KITTITAS COUNTY DEPARTMENT OF PUBLIC WORKS

MEMORANDUM

TO: Allison Kimball, Community Development Services
FROM: Christina Wollman, Planner II *aw*
DATE: February 5, 2009
SUBJECT: Clint Short Plat SP-08-00054

SHORT PLAT NO. _____
KITITAS COUNTY, WASHINGTON

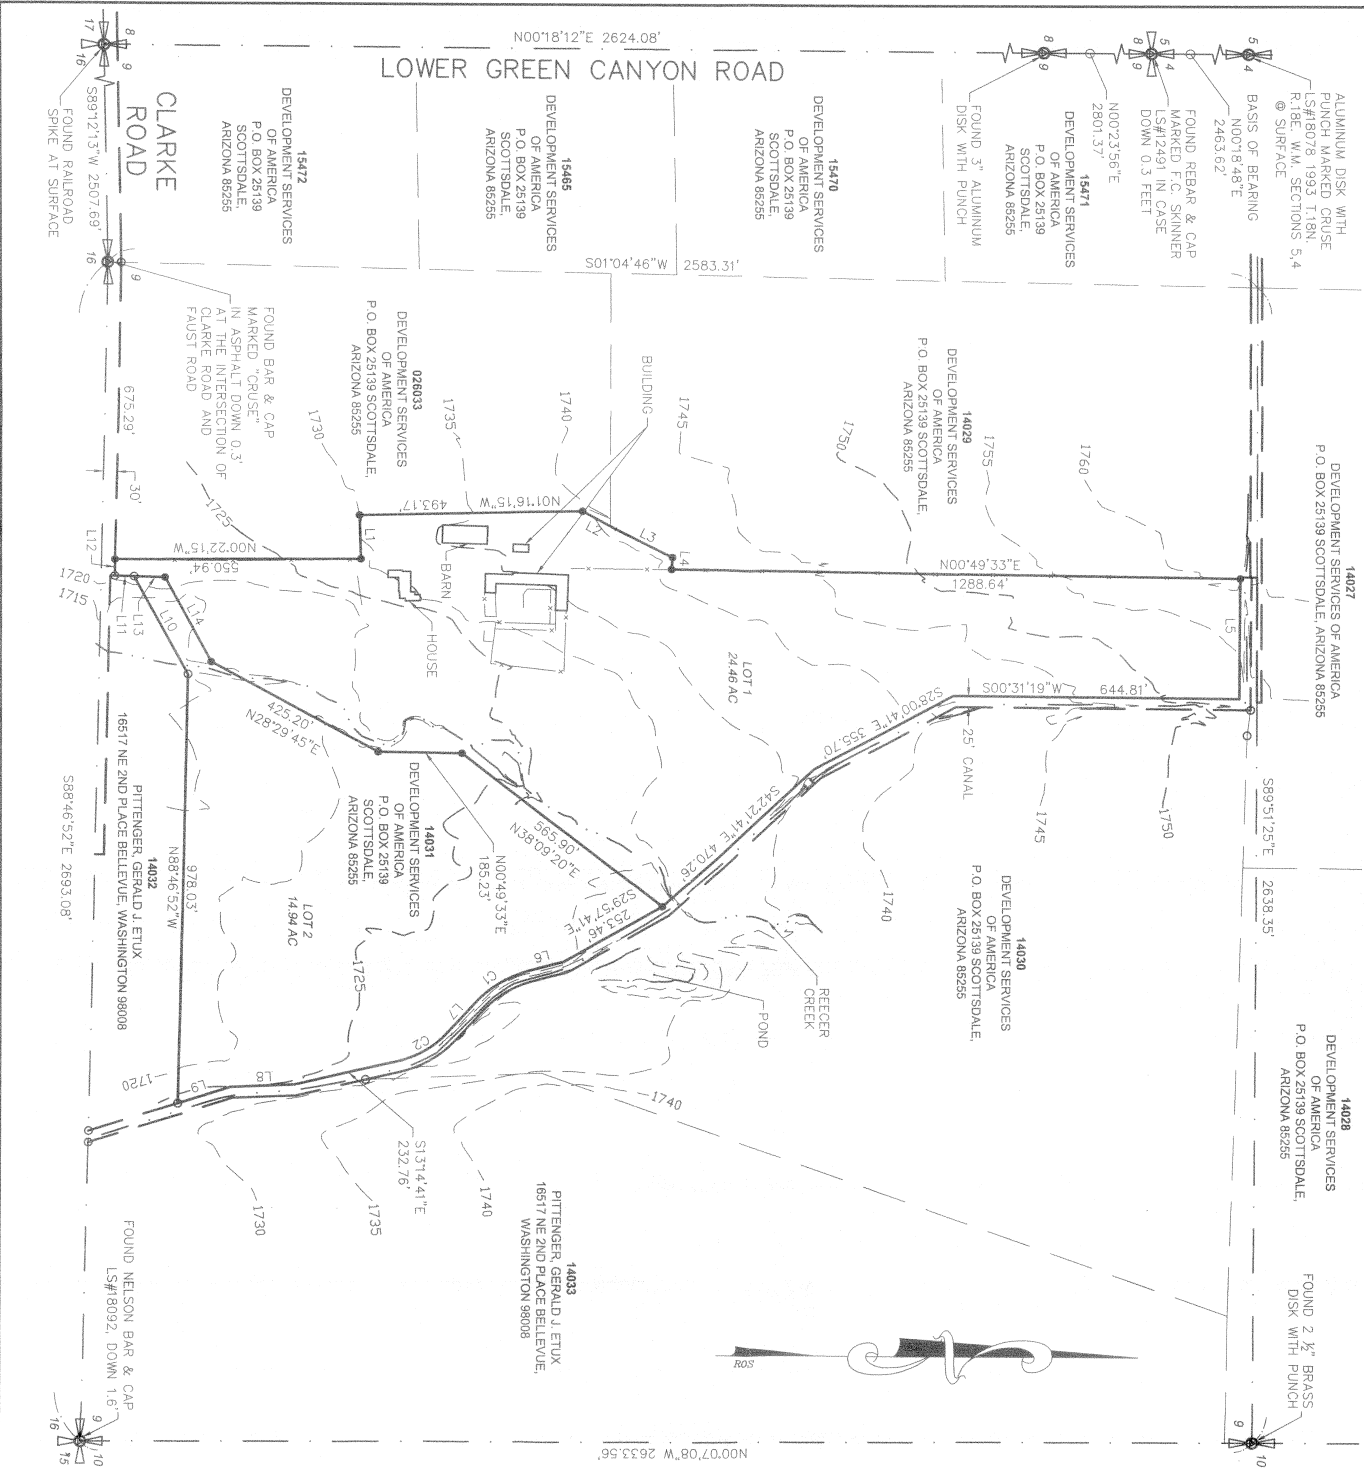
- Access:** An access easement with a width of at least 20' shall be established across Lot 1 for the benefit of Lot 2. The access shall be constructed as a joint-use driveway.
Joint-Use Driveway: A joint-use access shall serve no more than two tax parcels. See Kittitas County Road Standards, 9/6/05 edition.

- Access easements shall be a minimum of 20' wide. The roadway width shall have a minimum width of 12'.
 - The surface requirement is for a minimum gravel surface depth of 6".

- Reecer Creek Crossing:** The Washington Department of Fish and Wildlife shall be contacted for any requirements for constructing a crossing or bridge over Reecer Creek. If a bridge is required, it shall be constructed to the requirements of these agencies and the 2006 International Fire Code. The bridges shall be certified by a licensed engineer familiar with bridge design, construction and load ratings. The certification shall be submitted to Public Works prior to receiving a building permit.

3. Clarke Road Right of Way: The entire Clarke Road right of way shall be shown. The right of way shall be clearly delineated to avoid confusion between lot lines and section lines.
4. Plat Approvals: All plats must show the acceptance signature of the County Engineer. The acceptance block shall be as follows (per KCC 16.24.170):
